**WELWYN HATFIELD BOROUGH COUNCIL
ASSISTANT DIRECTOR (PLANNING)**

DELEGATED APPLICATION

Application No: 6/2023/0292/HOUSE
Location: 32 Fordwich Road Welwyn Garden City AL8 6EY
Proposal: Installation of rooflight and raise existing flat roof to facilitate partial garage conversion.
Officer: Mr Raymond Lee

Recommendation: Granted

ADDRESS:	32 FORDWICH ROAD, WELWYN GARDEN CITY, HERTS		
DRAWING TITLE:	PROPOSED PLANS & ELEVATIONS		
DRAWING STATUS:	PROPOSED	SCALE:	1:100
DRAWN BY:	DP	DATE:	JAN 2023
DRAWING NO.:	P100	REVISION:	C

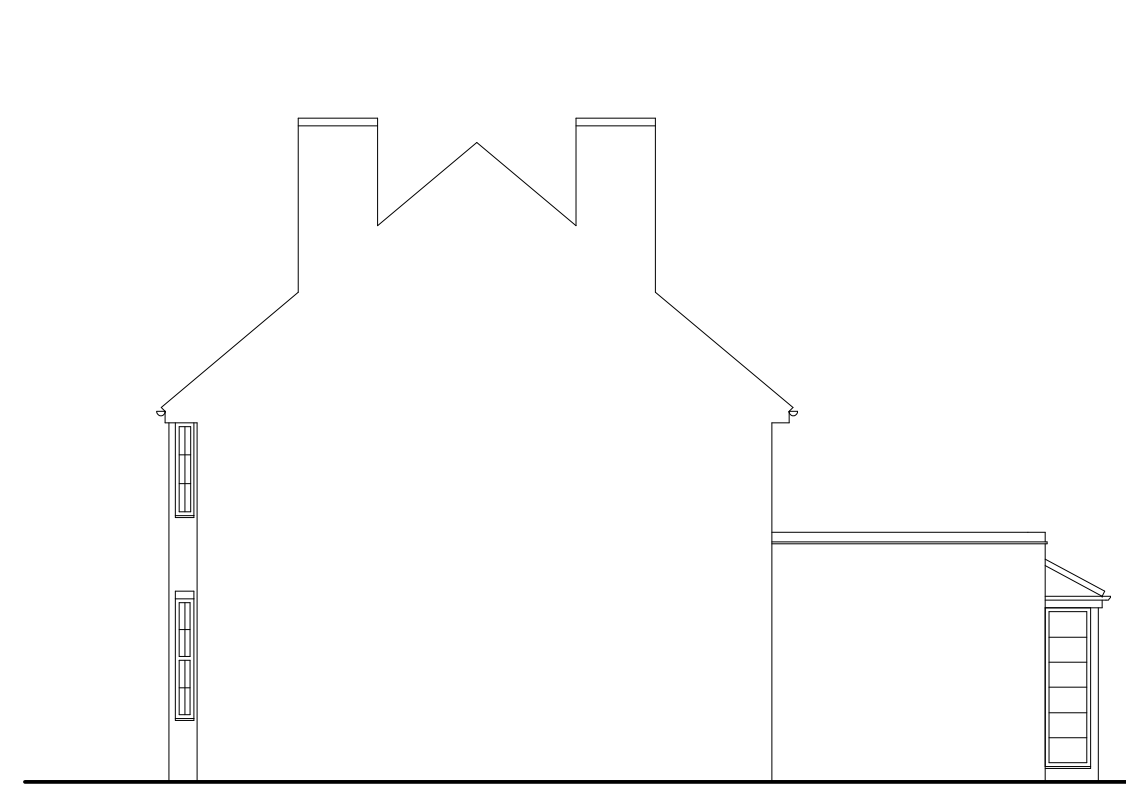
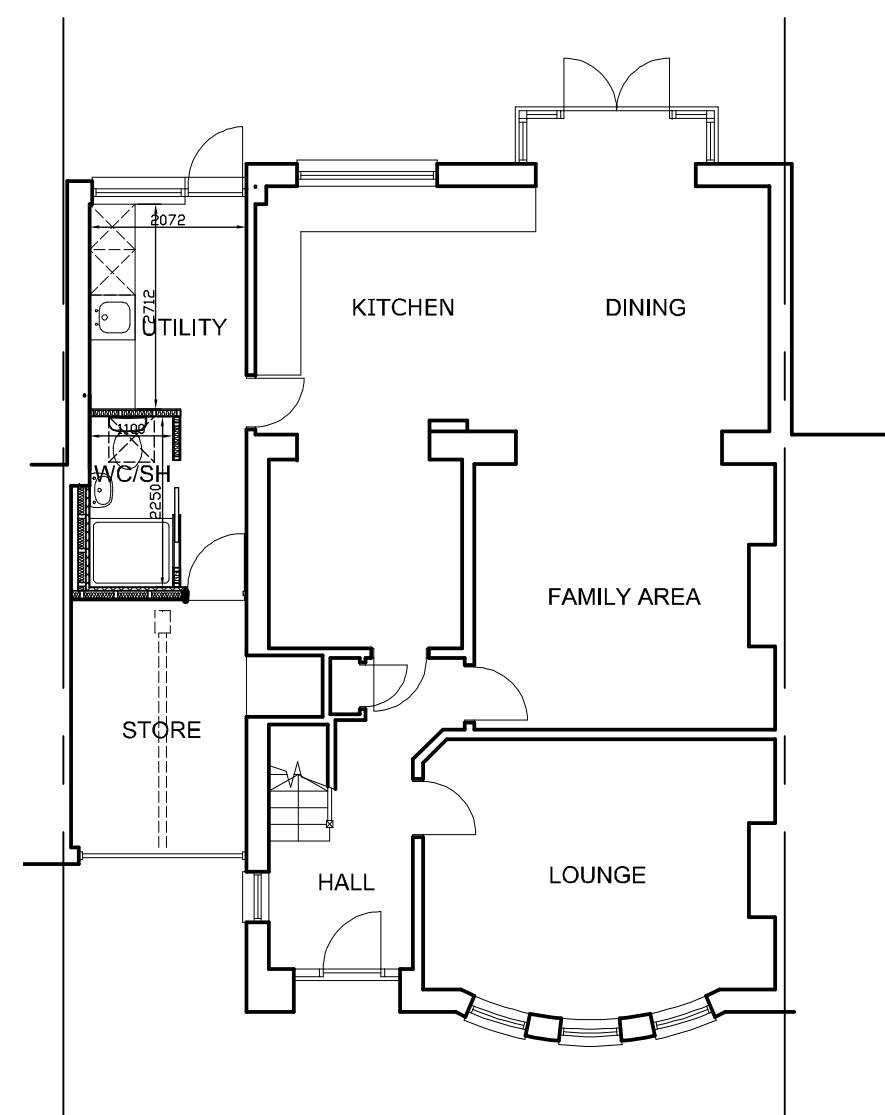
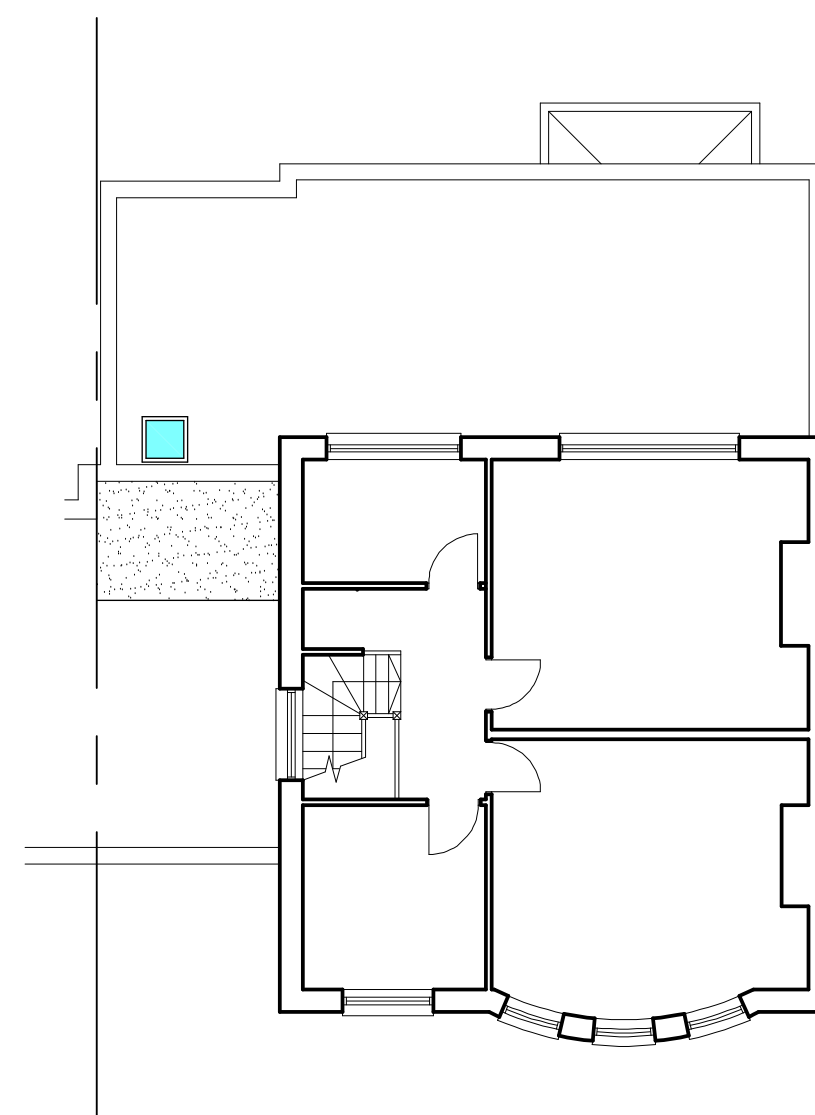
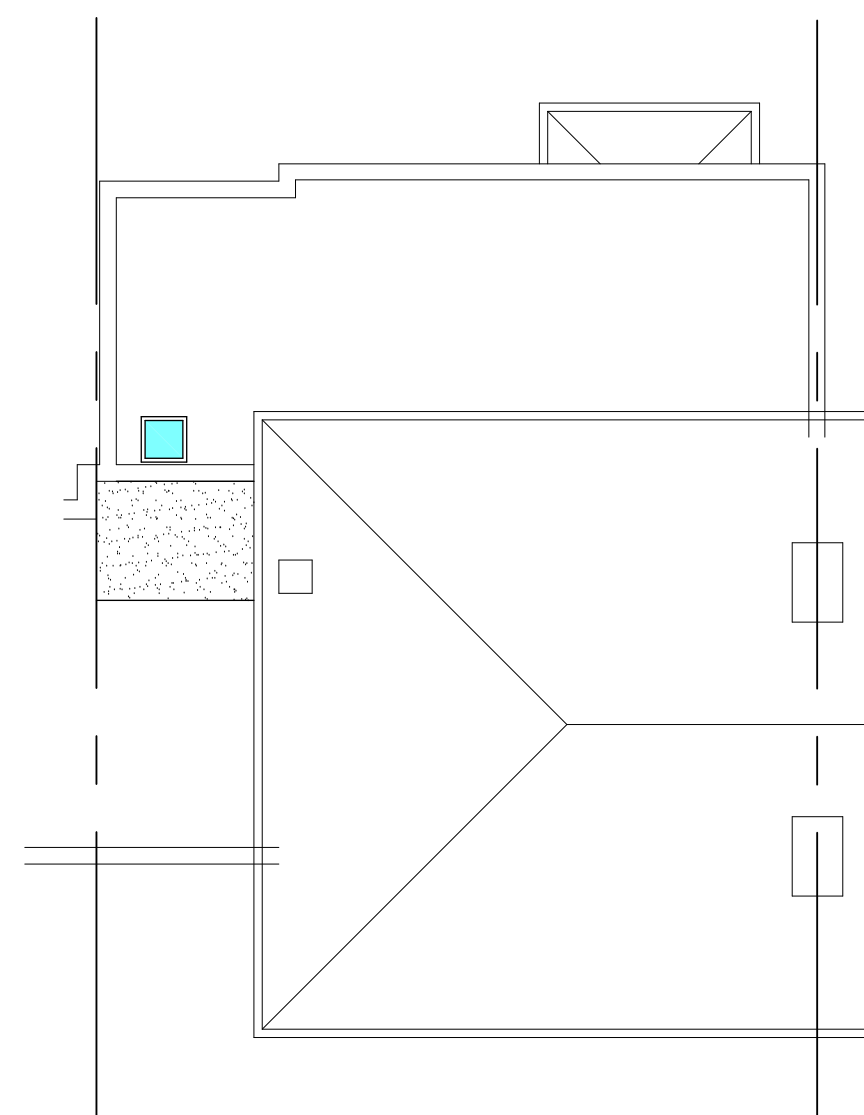
<input checked="" type="checkbox"/> Yes <input type="checkbox"/> No Comment (if applicable): <p>In this case, the proposals seek a partial conversion of the existing garage which will be facilitated by raising a section of the existing flat roof and by inserting a single roof light. The slight height increase of a small section of the existing roof by approximately 0.25m would result in a stepped roof feature which, although it creates an inconsistent roof form in design terms, is not considered to result in a detrimentally harmful change to the property when viewed from the street given that it is set towards the rear of the building. In addition, the roof light would also be set back and is unlikely to be visible from public vantage points. As a result of the modest scale of the development and the limited views of it, the proposal would not result in a disproportionate addition and, subject to matching materials, would be in keeping with the design and appearance of the original dwelling.</p> <p>Overall, the impact upon the character and appearance of the dwelling and the Conservation Area would therefore be acceptable, in compliance with the National Planning Policy Framework, Policies D1 and D2 of the District Plan and Policy SP9 and SADM15 of the emerging Local Plan. The proposal would also comply with the provisions of Section 72 of the Planning (Listed Building and Conservation Areas) Act 1990 in preserving the Conservation Area</p>

In this case, whilst the existing garage is to be partially converted into additional living accommodation, the internal dimensions of the existing garage would not be considered adequate for a modern family sized vehicle. The submitted plans show that there will be sufficient space on the driveway for the parking of at least two vehicles. This is considered adequate given that the site is within a reasonable walking distance to the town centre, bus stops and the train station. No concerns are therefore raised with respect to parking provision and highway safety.
